## Engineers Comments Regarding Surface Water Drainage

| <b>Application Reference:</b>   | A/183/25/DOC                                                                                                         | <b>Reviewer Reference:</b> | ADC/EXT5/AF |
| <b>Site Name:</b>               | Land north of Mayflower Way Angmering                                                                                |                            |             |
| <b>Application Description:</b> | Approval of details reserved by condition imposed under A/122/23/PL relating to condition 11-surface water drainage. |                            |             |

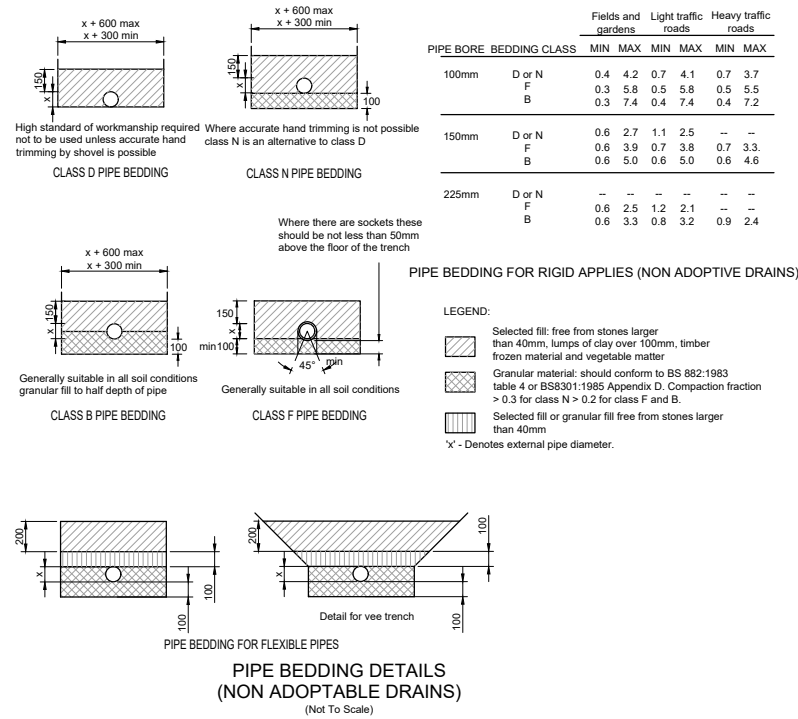
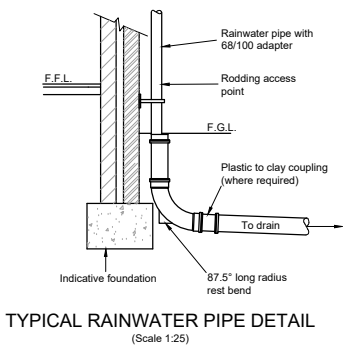
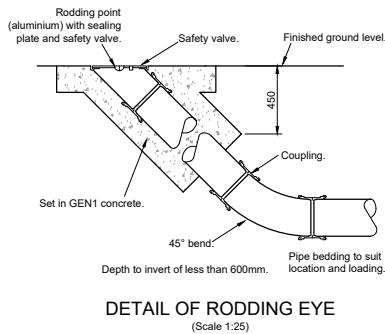
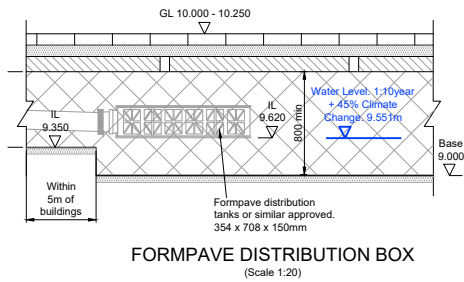
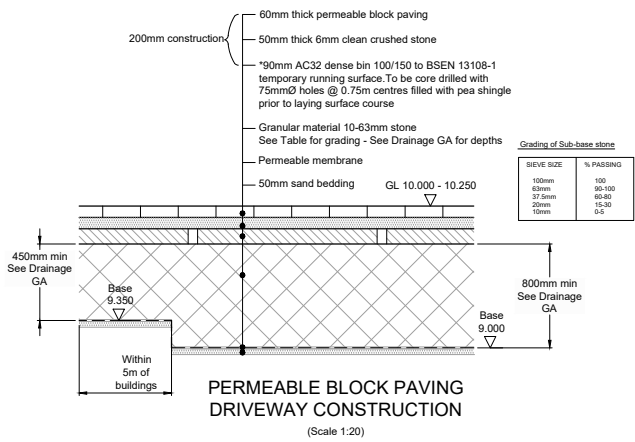
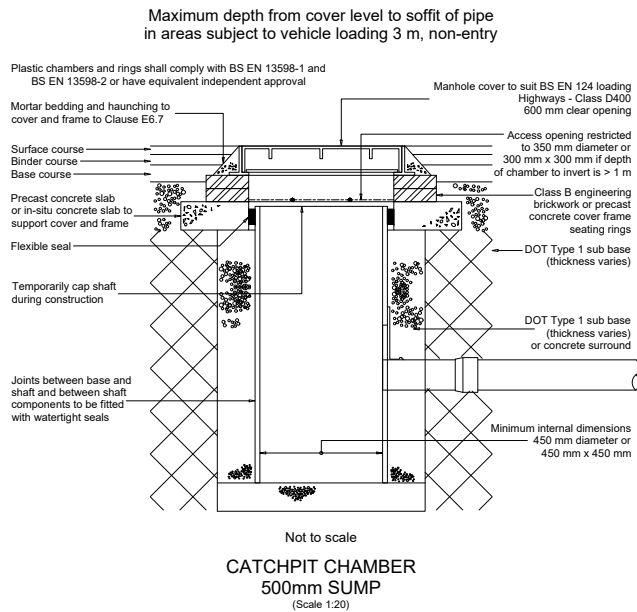
| 4 | <p>The drainage layout should show a Stage 4 Technical Design rather than Planning Strategy Plan and include full levels design. The layout should show the permeable pavement base levels rather than depths.</p> | <p>Appendix 5 of the Discharge of Drainage Condition 11 technical note provides the technical detail required for construction, including the proposed FFL, a manhole schedule with cover and invert levels, chamber type, and spot levels on the 'For Approval'</p>                                                                                                                                                                                                                                                                                                                                                                                                                             | <p>Response accepted. No further comment.</p> |  |  |

|   |                                                                                                                                                                                                                            | Proposed Drainage Strategy Plan Rev C and the base levels of the permeable pavement on the Construction Drawing 60 B.                                                                                                                                                                                                                                                                                                                                                                                                                                                                                  |                     |  |  |

Appendix 7
Exceedance Flow Route Plan

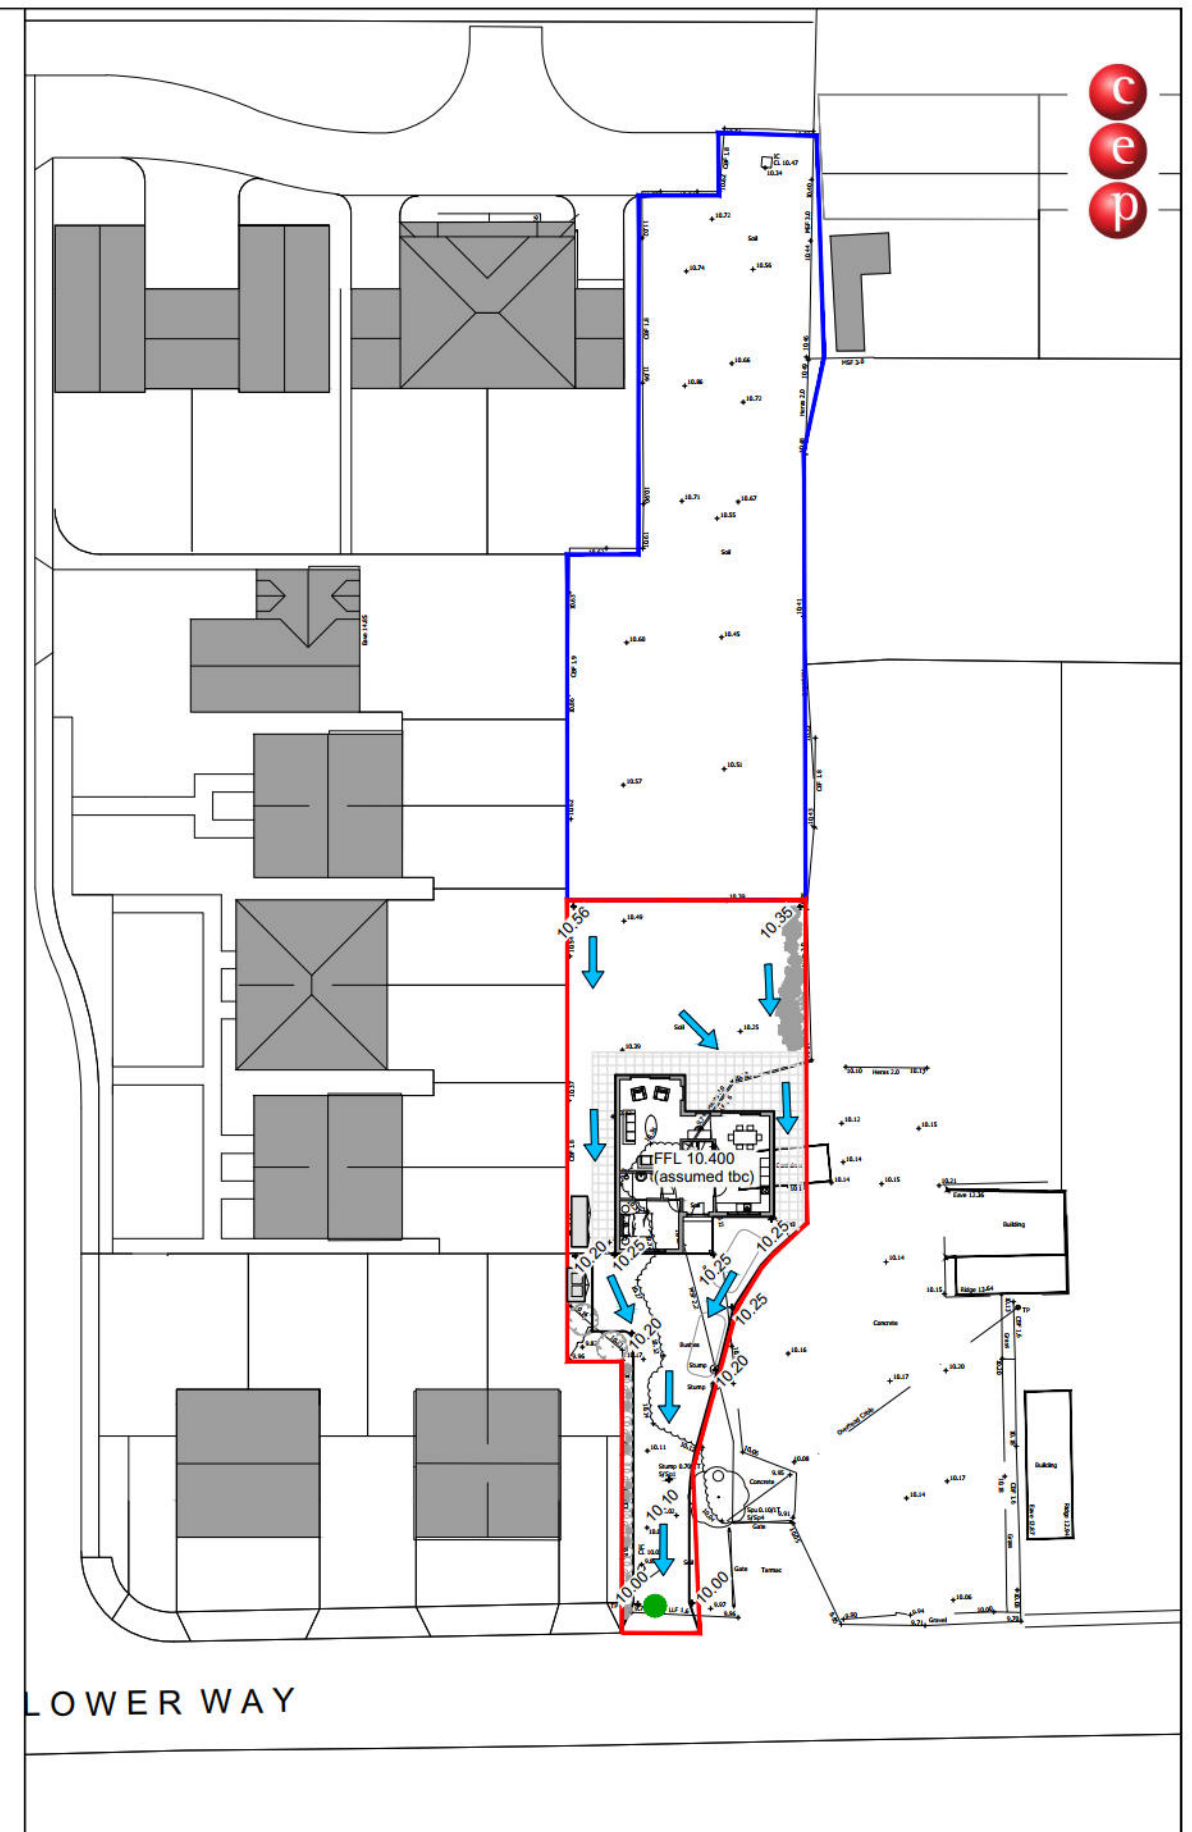
| 2 | The paved area around the house is impermeable and appears to drain towards the permeable pavement but is excluded from the drained area. | The ground levels in the garden generally fall to the south around the dwelling as shown on the exceedance plan. However, paving adjacent to the dwelling will be laid at a minimum 1:40 slope downwards away from the dwelling and on to the garden. Drawing 16_Exceedance Flow Route Plan is attached.                                                                                                            | Response accepted. No further comment. |  |  |
